New Widefield PK-8 School
 11060 Fontaine Blvd., Widefield, CO
Widefield School District 3
 1820 Main Street
 Colorado Springs, CO 80911

Development Plan

Landscape Plan

LS1.0

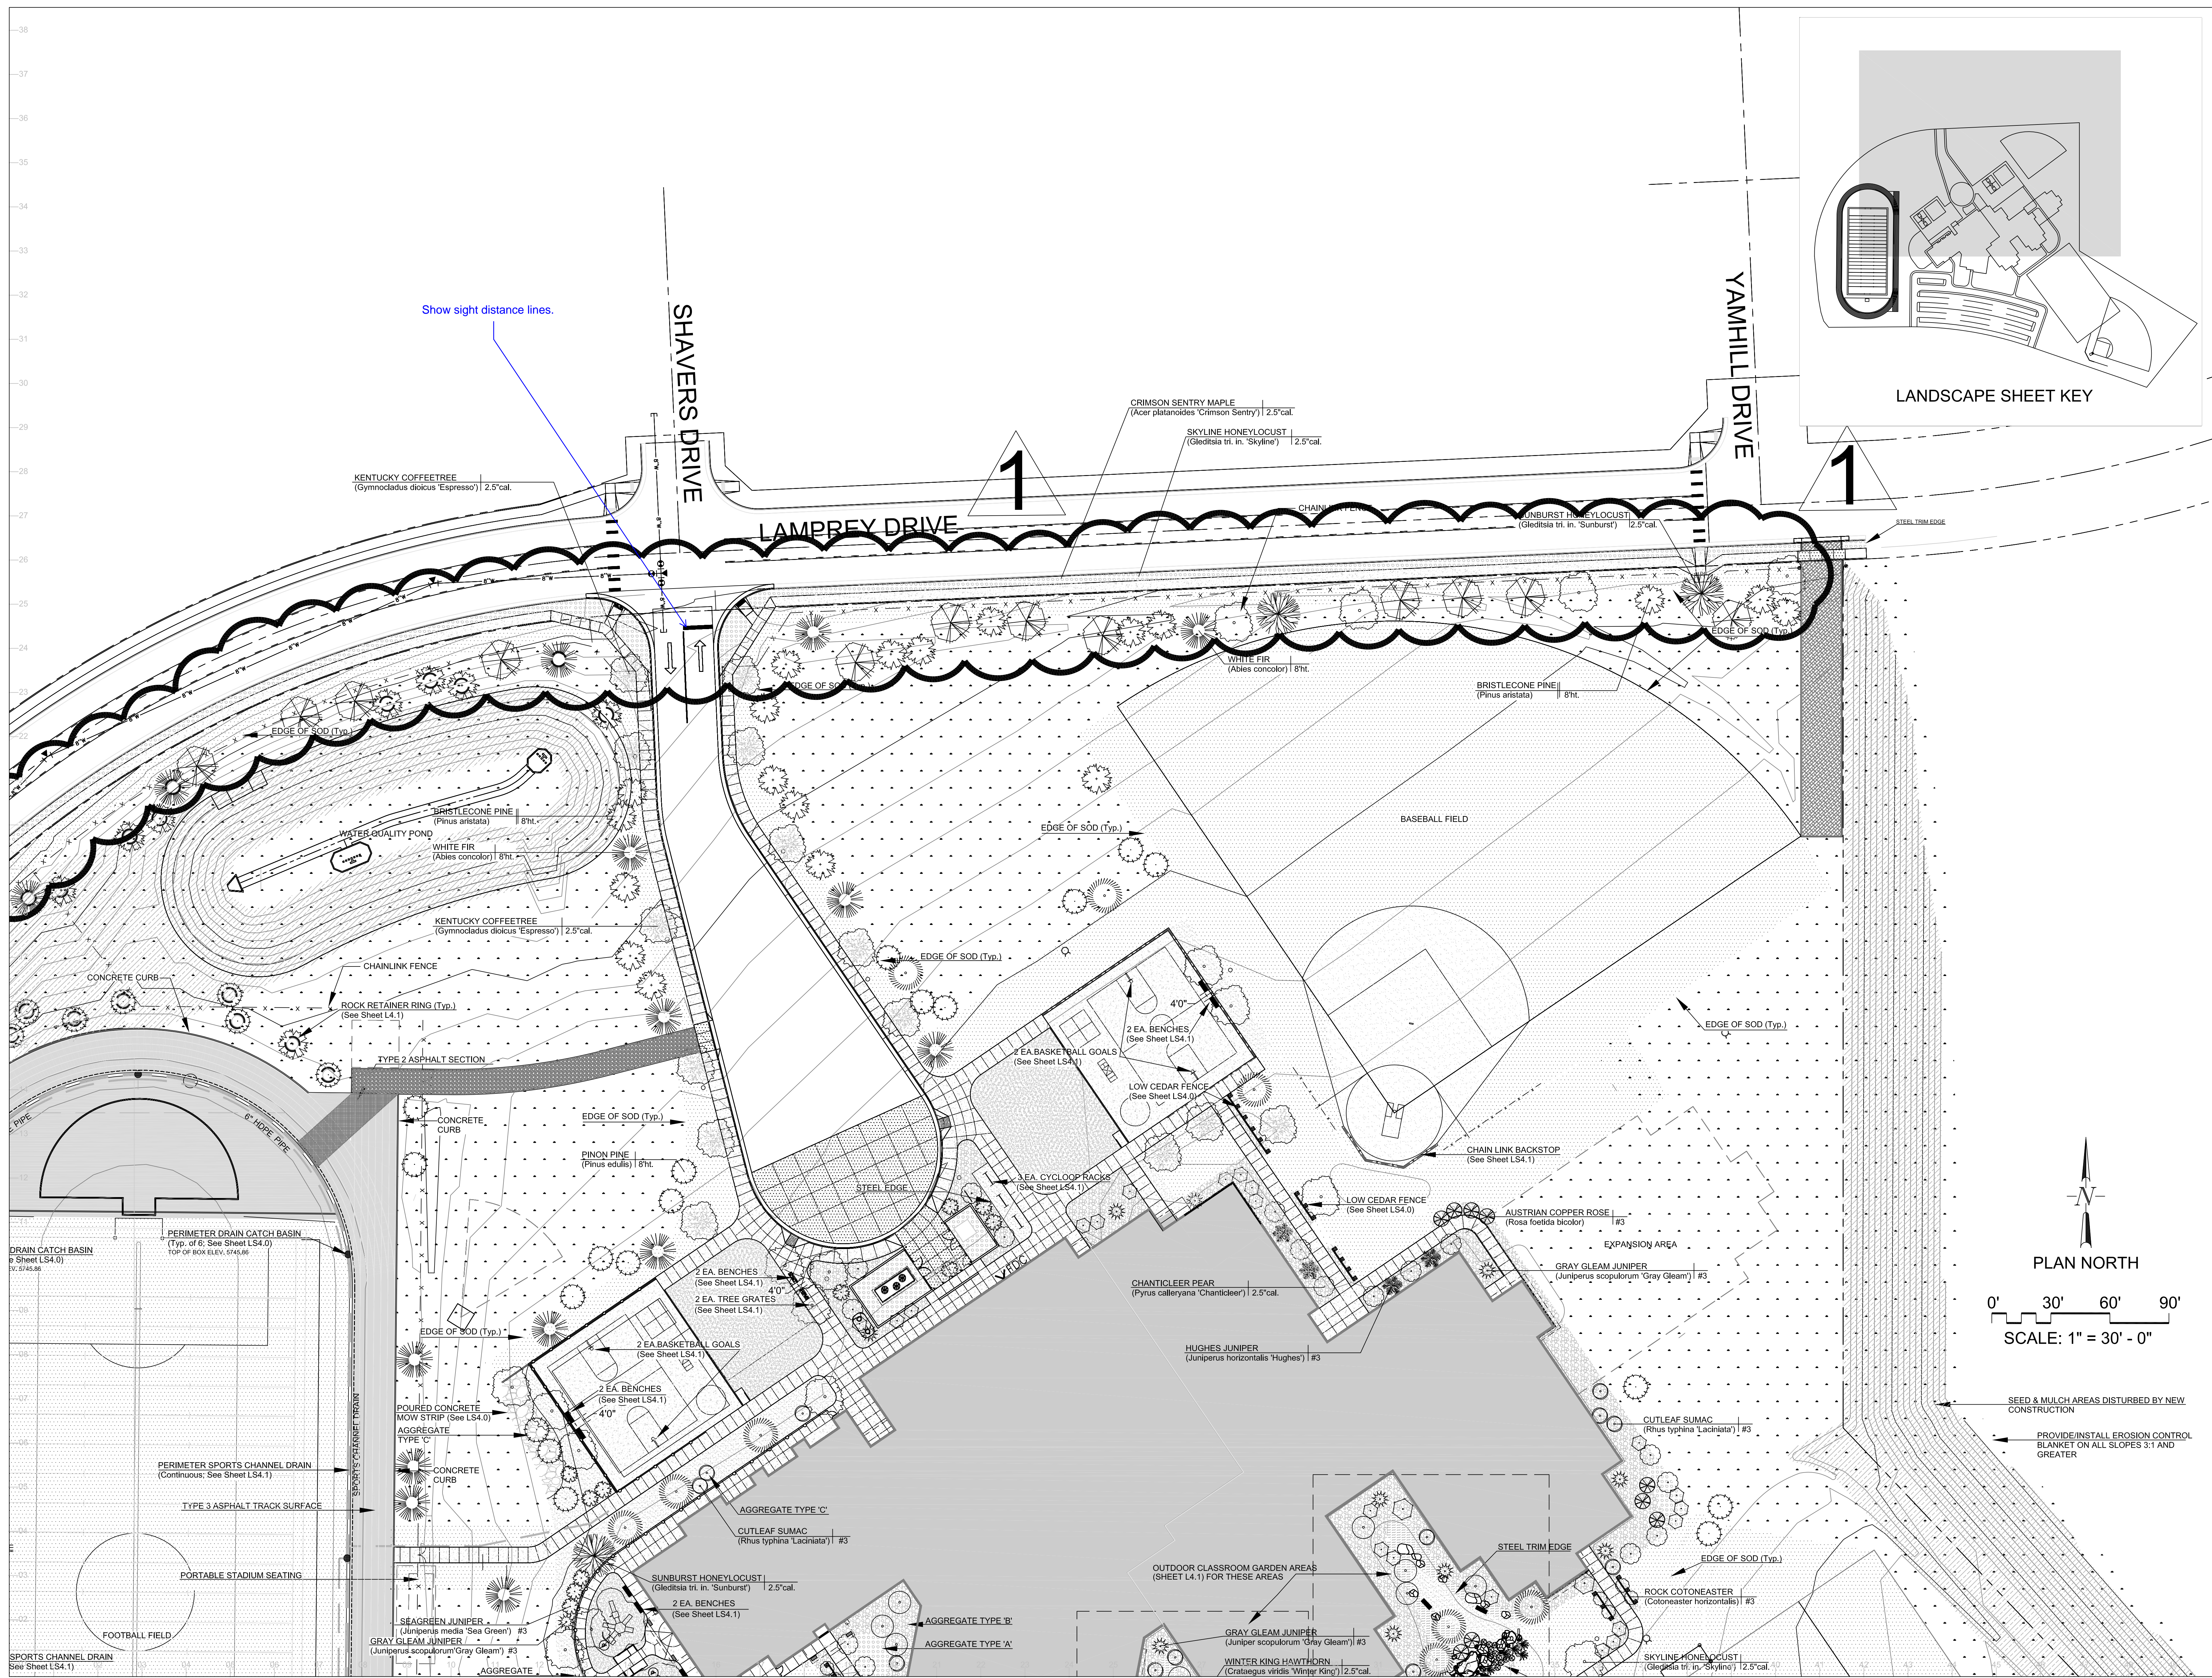
PUD calls for 35' setback depth for landscaping - show that.

Include a table of how many trees are required and provided per the PUD guidelines that were attached in another comment.

Verify sight distance and adjust trees if necessary.

LS2.0

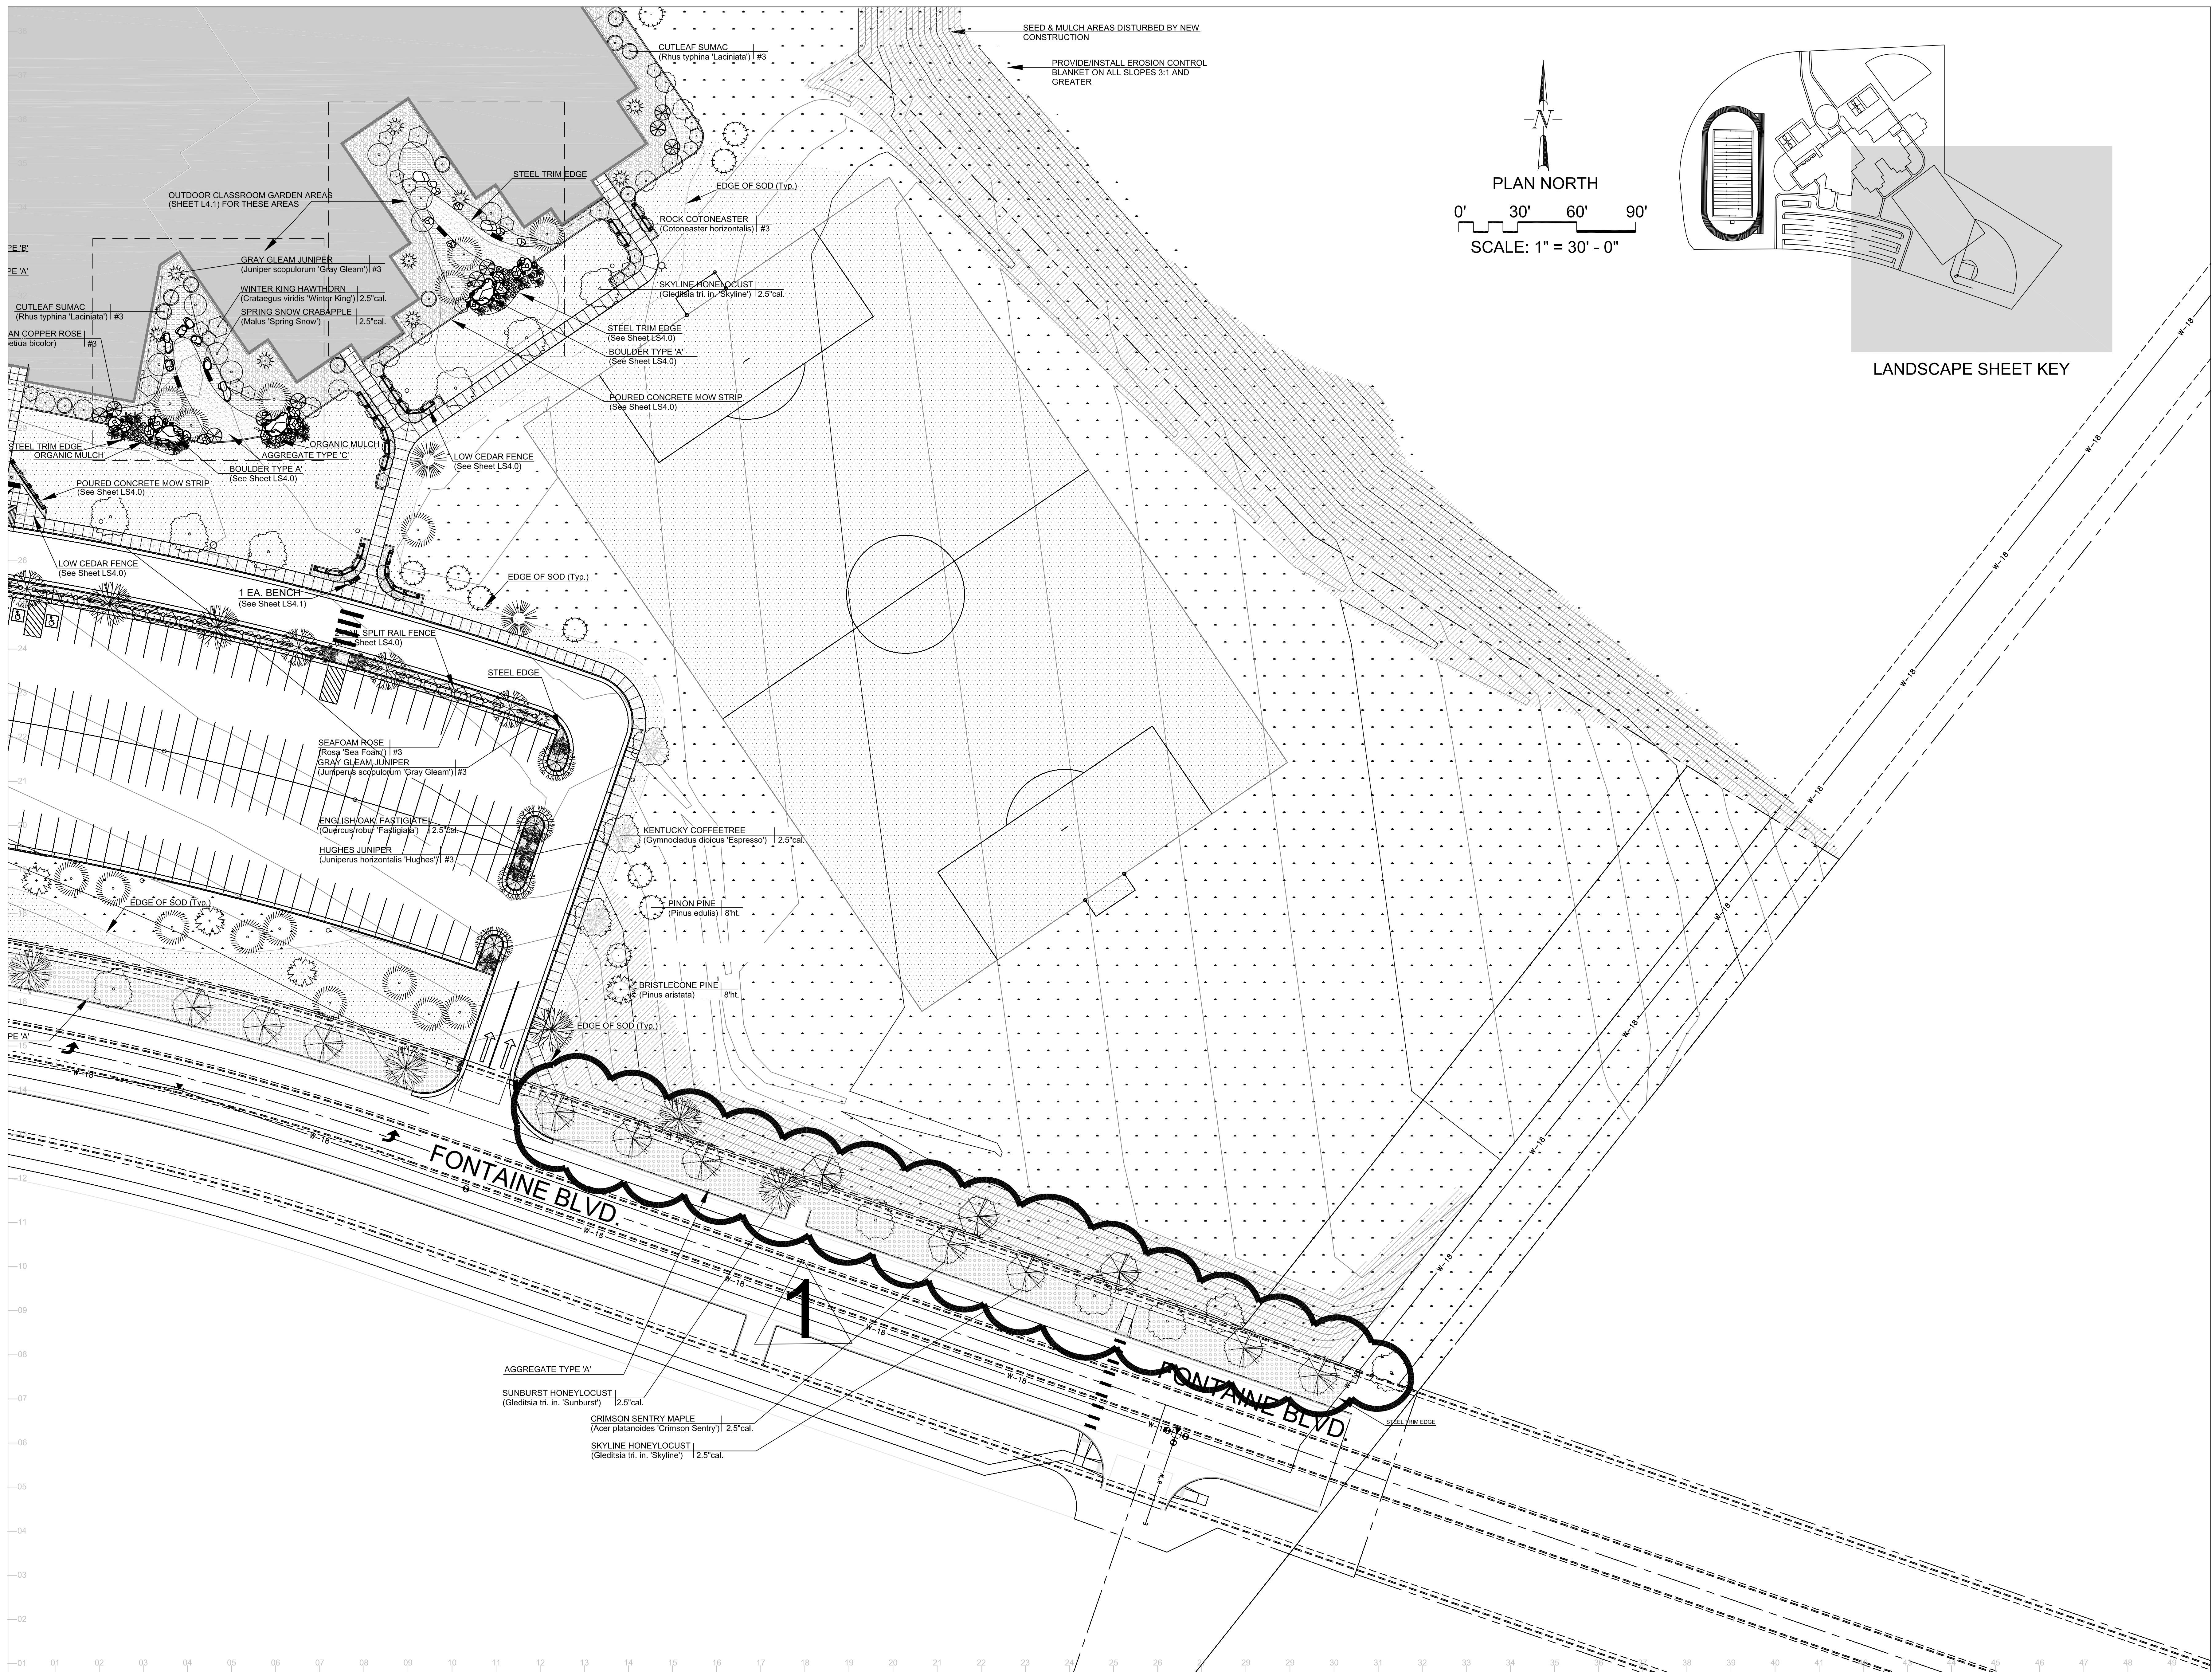
Make sure tree's do not cause too much debris in the Right of Way. - License Agreement w/ County Engineer.

Verify sight distance and adjust trees if necessary.

Verify sight distance and adjust trees if necessary.
